Kirklees Metropolitan Council

Application Reference: 2025/91542

**Site: Erection of 40 dwellings and associated works, including formation of new
vehicular access and erection of cricket netting**

Sport England Reference: PA/25/Y/KK/71268

6. Proposed Cricket Net

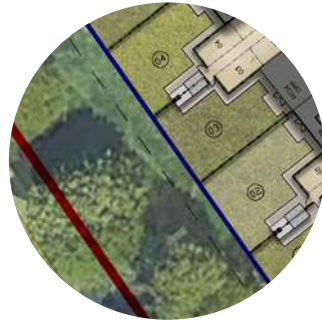
The applicant has undertaken a ball strike risk assessment which concludes that ball stop mitigation in the form of ball stop fencing is required on or near the boundaries of the cricket club. However, the ball strike risk assessment has been undertaken on the basis that recreation cricket is played at the adjacent cricket ground:

As such, the risk assessment has considered the incorrect level of play and ball trajectory modelling for cricket. Therefore, the proposed ball stop mitigation does not relate to the correct level of play and could be insufficient to prevent any ball strike. This could lead to damage to both people and property in the new proposed development.

In light of the above, Sport England **objects** to the application because of the prejudicial impact it could have on the adjacent cricket ground as set out above.

1. A ball strike risk assessment, undertaken by a suitably qualified consultant, that examines the ball trajectory for cricket for the correct level of play.
2. If ball strike is identified as an issue, then details of the design, specification and layout of any ball strike mitigation (for example ball stop fencing) should be provided. This should also include details of how any ball strike mitigation will be managed and maintained. Any ball strike mitigation

provided should not have any encroachment onto the existing playing field/cricket ground and there should be no expectation that any maintenance and management is undertaken by the cricket club or other sport users. This should be undertaken by the applicant.
